From: Michael Eastham <Michael.Eastham@arun.gov.uk>
Sent: 06 November 2019 09:38
To: Planning.Responses <Planning.Responses@arun.gov.uk>
Subject: FW: Saltbox - BE/110/19/DOC - Conditions 9 and 10

From: Roger Spencer <Roger.Spencer@arun.gov.uk>
Sent: 05 November 2019 16:21
To: Michael Eastham <Michael.Eastham@arun.gov.uk>
Cc: Paul Cann <Paul.Cann@arun.gov.uk>
Subject: RE: Saltbox - BE/110/19/DOC - Conditions 9 and 10

We have now looked at your further proposals, our comments are below;

CLASS Z BEDDING
CONCRETE SURROUND

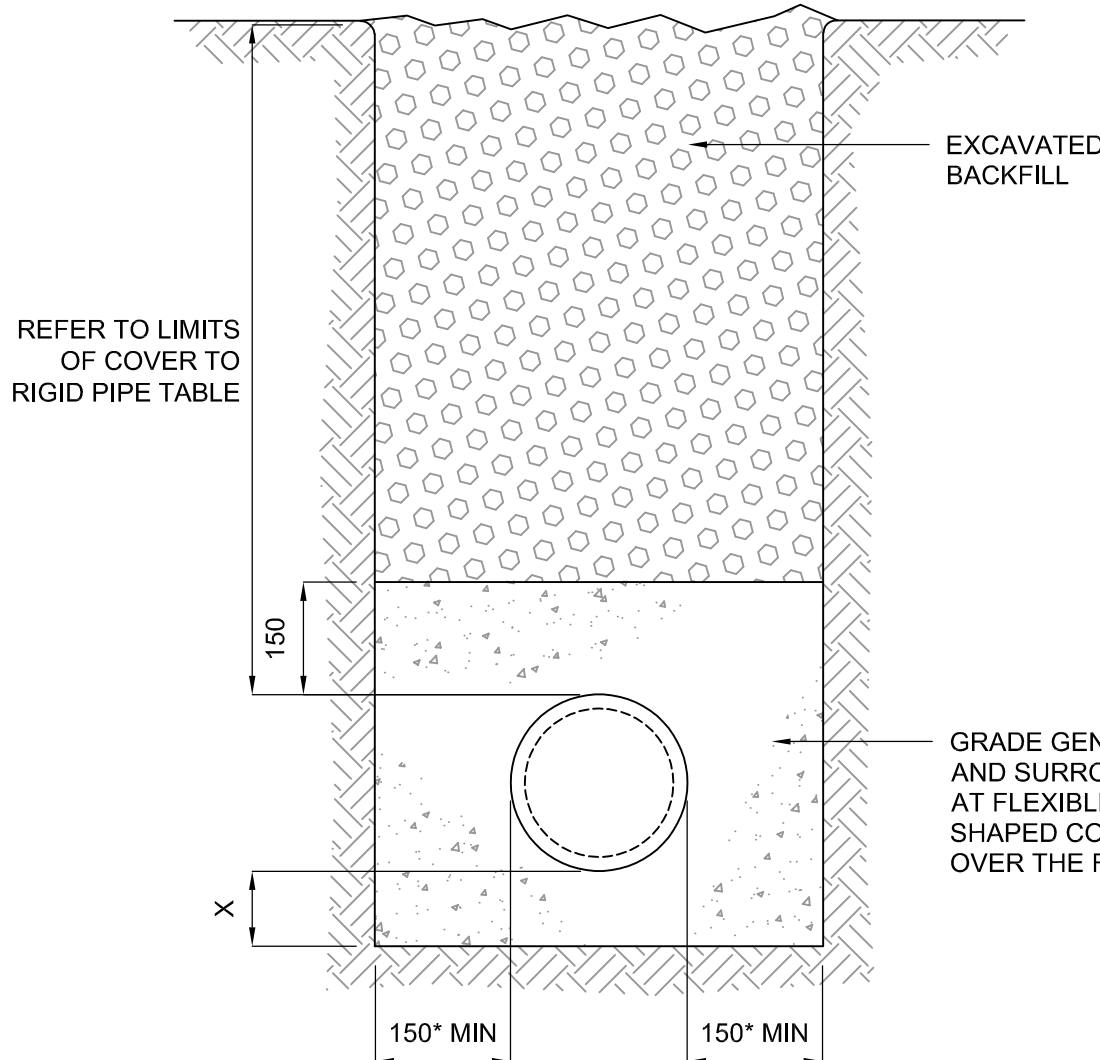
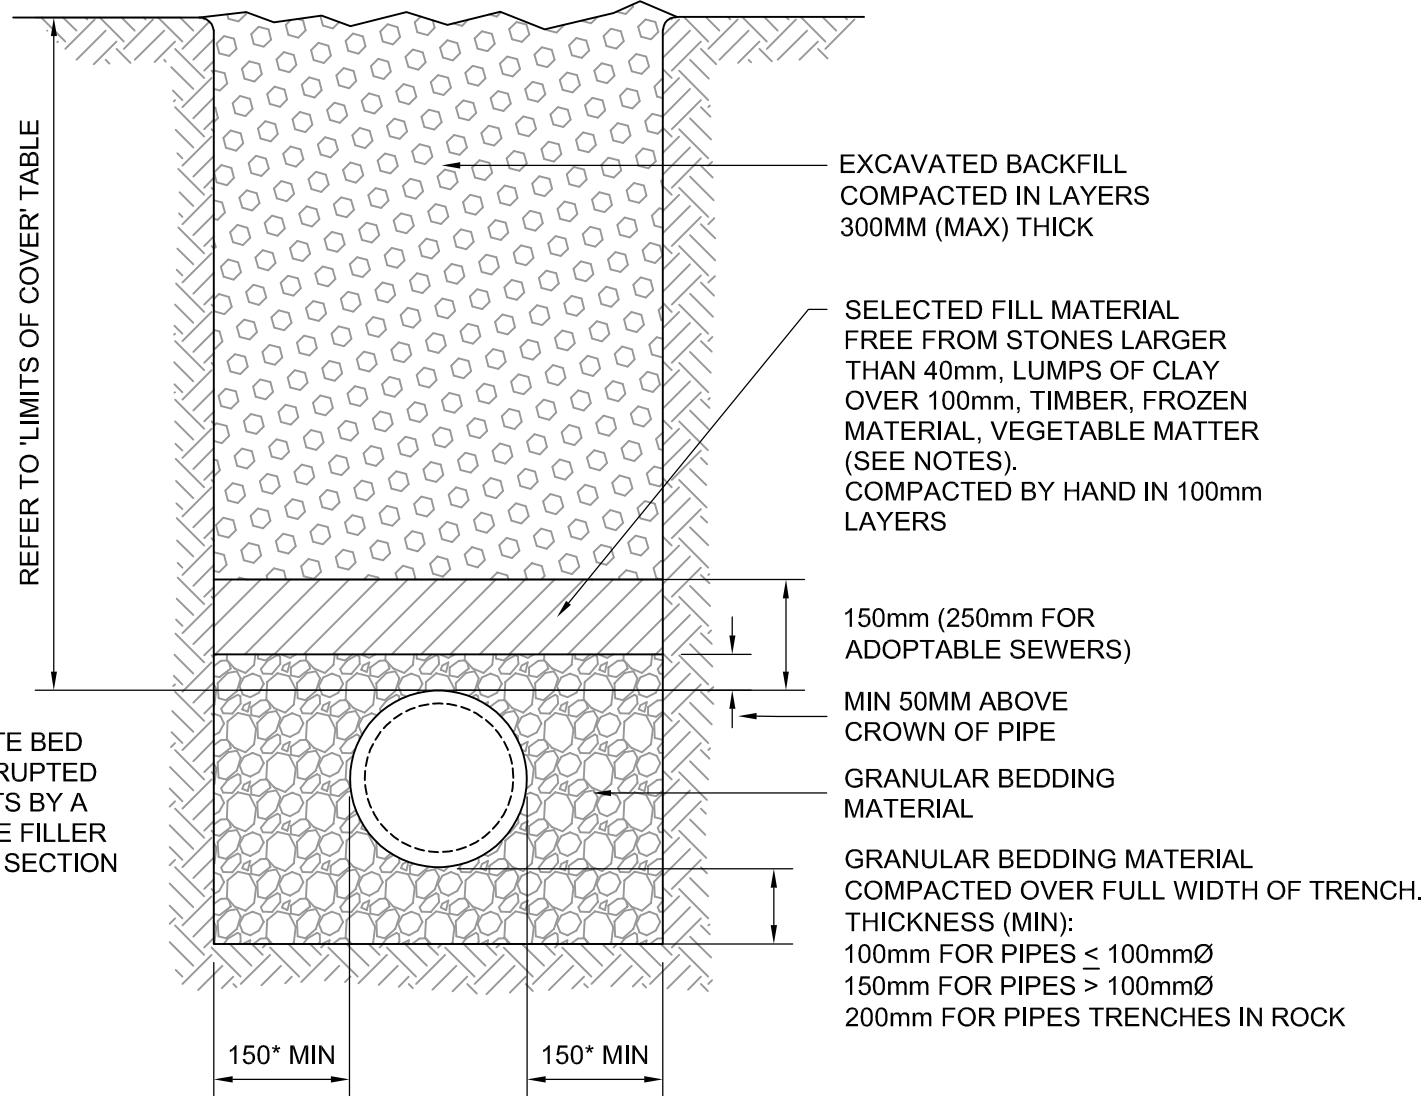
28. Pipe bedding detail – min. 150mm full bed & surround for class S and class Z. Add note; All vehicular areas <1.2m cover to receive class Z bedding.

SAL-HYD-00-ZZ-DR-C-7010

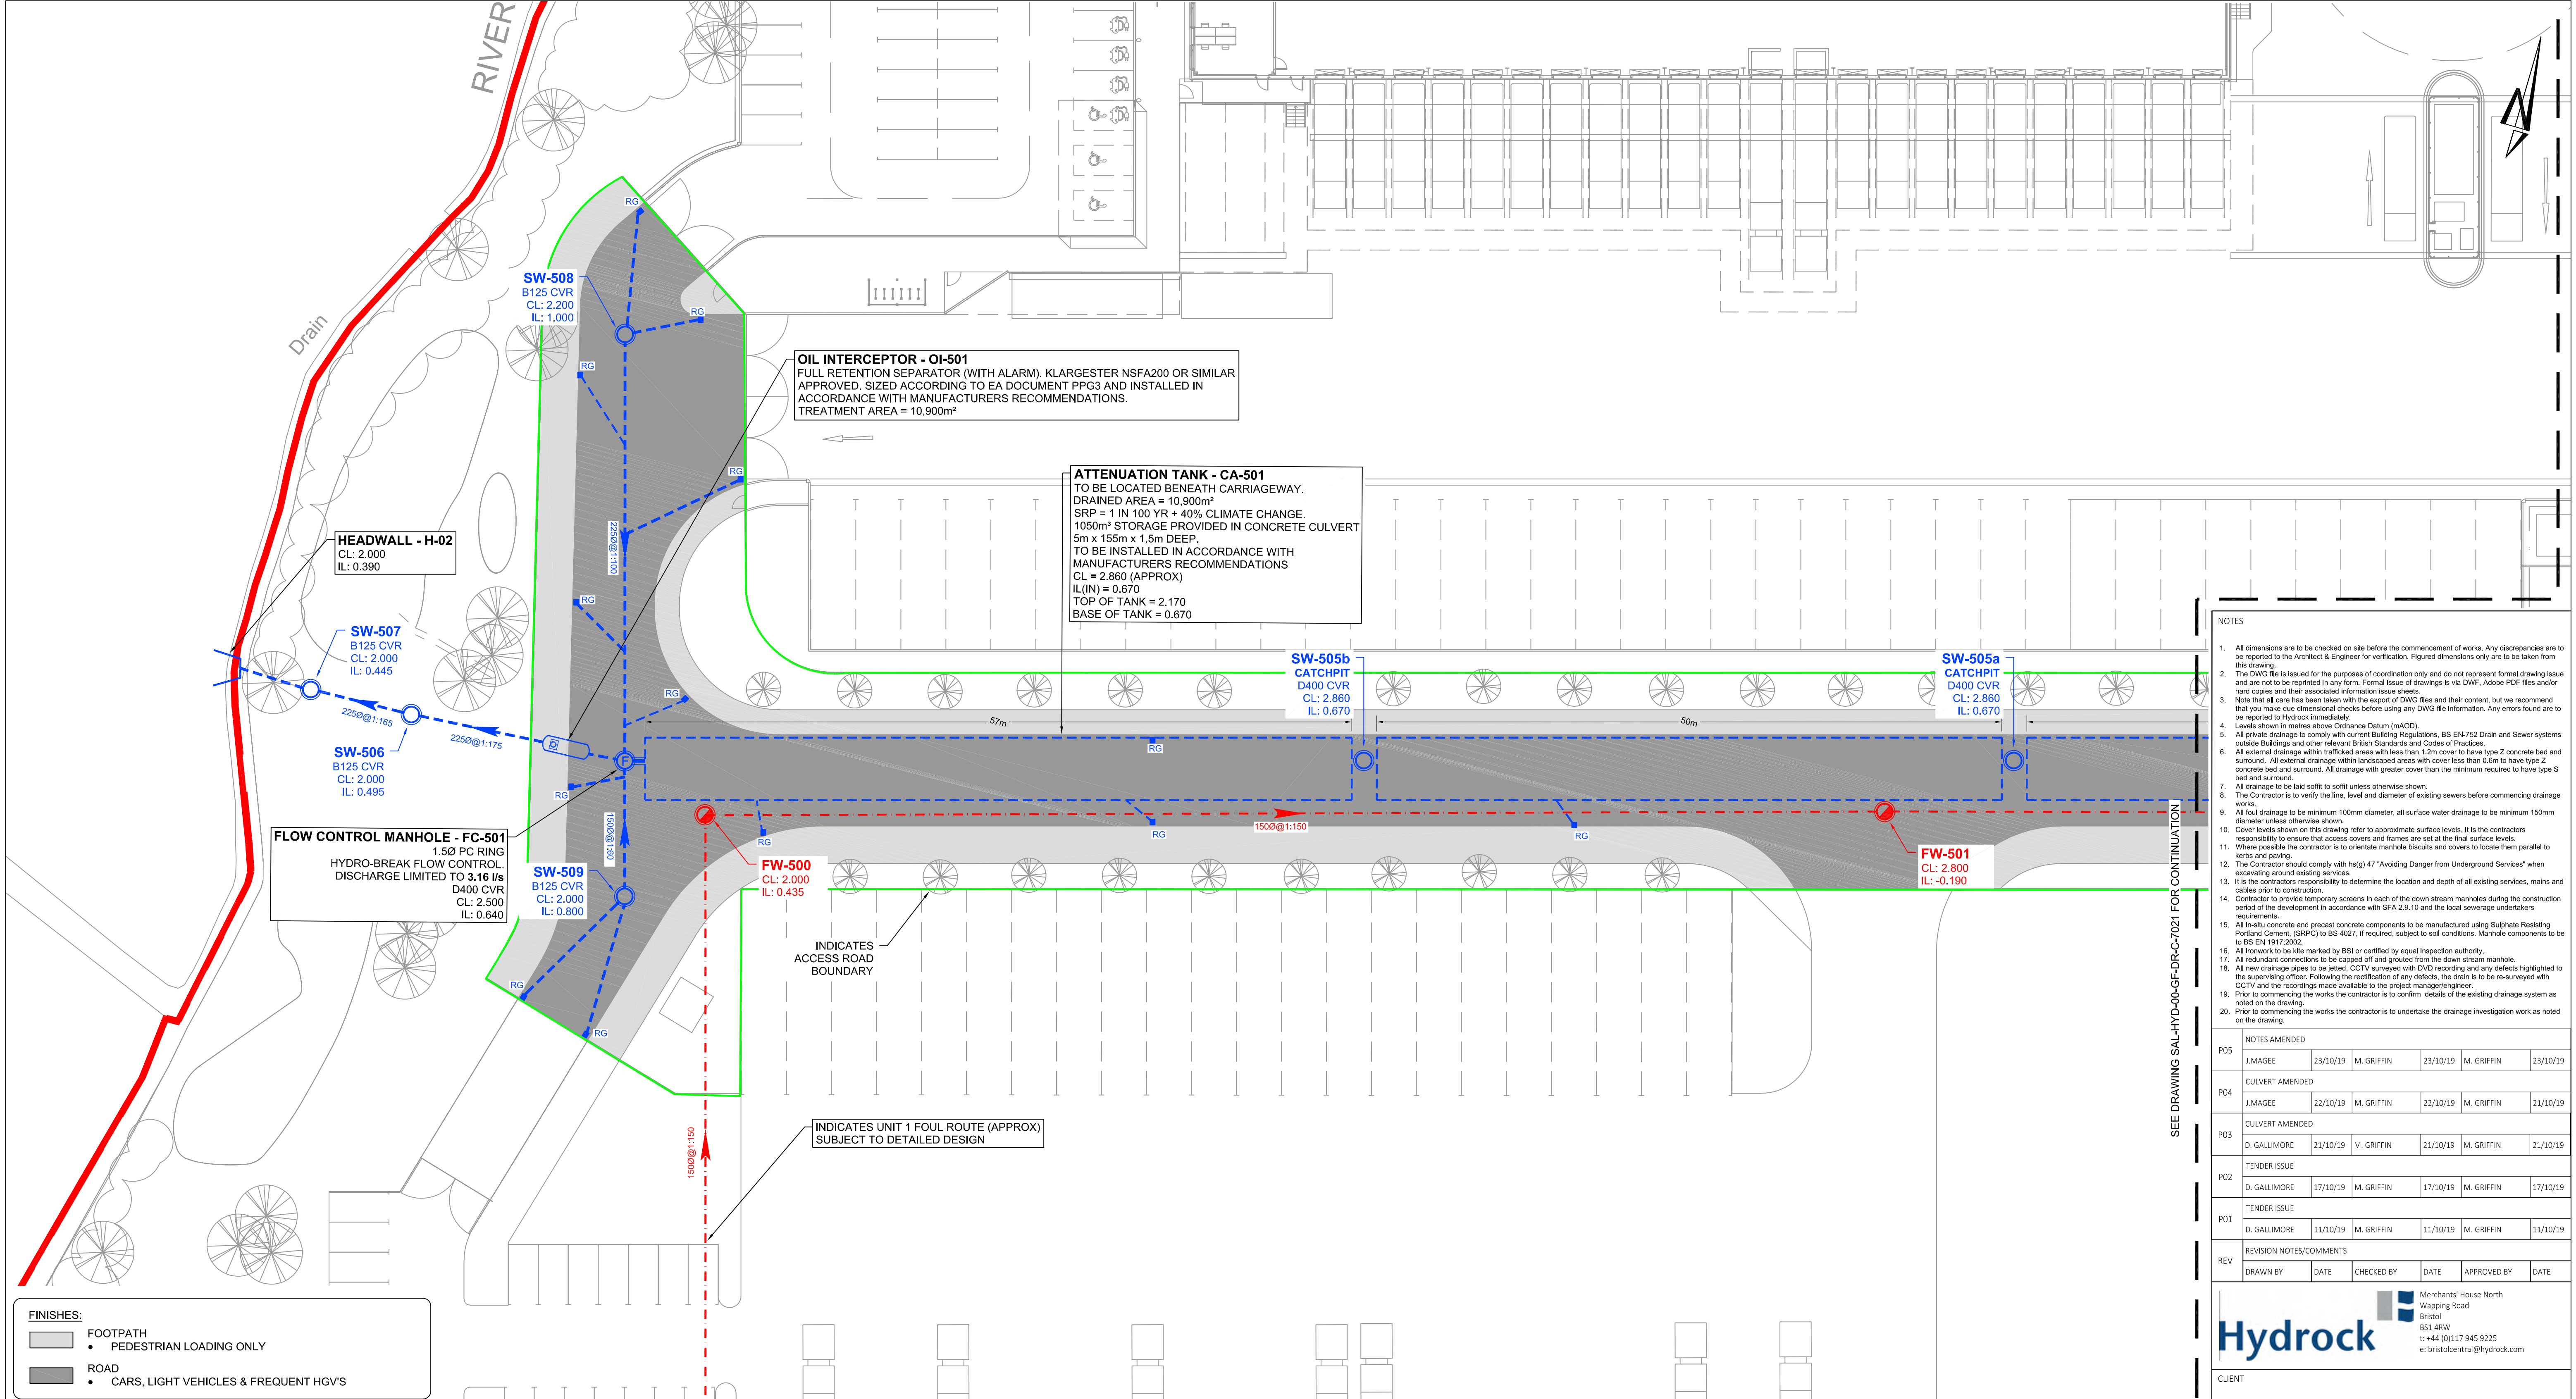
1. The 450mm pipe on the north side of unit 2 which discharges at the headwall – assumed to be draining a future phase, however, how are these flows being attenuated?
2. SW-1002 to SW-1004 needs its gradient improving to provide self-cleansing velocity of 1 m/s at full bore.
3. SW-1004 to SW-1005 – Levels indicate no gradient.
4. Manhole SW-1104 150mm outlet from flow control chamber shown connecting invert to invert with 450mm pipeline – needs to be soffit to soffit.
5. Headwall – Althon model H3C not suitable for a 450mm pipe.
6. Pipeline SW-1002 to headwall is showing planting over/within close proximity. Please remove as necessary.
7. Manhole SW-205a to be a catchpit.

8. Numerous pipelines are shown as 400mm diameter which is an unconventional diameter. Please adjust to 450mm.
9. Where road gullies are being connected to pipelines, oblique 45 degree junctions to be used, ensuring the connection is made at 10 or 2 o'clock, as per a clock face, assuming to the top of the pipe being connected to is 12 o'clock. Add note.

10. There are numerous types of road gully as per the construction detail. Specify which type applies to each gully.
11. Headwall – An activity permit is required from the Environment Agency for the connection to the 'main river'. This will include their agreement to the headwall construction, discharge of flows and erosion control measures. Add a suitable note.

12. Despite item 11, please include rocker pipes on the construction detail. Reference to drg. 7010 should refer to the layout arrangements rather than 'details'. A construction detail is required for the concrete protection slab pipe protection and the full extent of this type of protection shown on the drawings. A flap valve to be specified on the end of the pipe.

13. Geocellular tanks AT-201 and AT-202 – provide vent and a means to access crates for inspection.
14. Is there scope to reduce base level of tank AT-202 to say 0.85 to improve hydraulics?

15. Has any infiltration potential been ruled out for tanks AT-201 and AT-202? Please clarify.
16. Dependent on item 15, clearly specify on both construction details the permeable/impermeable membrane's, manufacturer/product name.

17. Control chamber FC-201 –drawing to be fully detailed ie. dimensions, ring diameter, materials, etc.
18. Control chamber FC-1001 – Not located on layout plans. Is this in relation to item 1?

19. Specify crate manufacturer/model, ensuring the chosen product is suitable for the anticipated vehicle wheel loadings/movements.
20. Manhole SW-213 – pipes to be laid soffit to soffit.

21. Manhole immediately downstream of tank AT-202 has differing reference on the plan and construction details.
22. Increase channel drains from 100mm wide to 200mm wide.

23. All manholes downstream of or receiving direct connections from channel drains to be catchpits.
24. Permeable paving sub base – specify as clean (no fines).

25. Increase fin drain outlet from 100mm diameter to 150mm diameter.
26. Manhole type 2 and catchpit manhole – include ring diameter table from SFA7.
27. Manhole SW-213 – is the cover level correct?

29. Specify pipe materials for all pipelines.
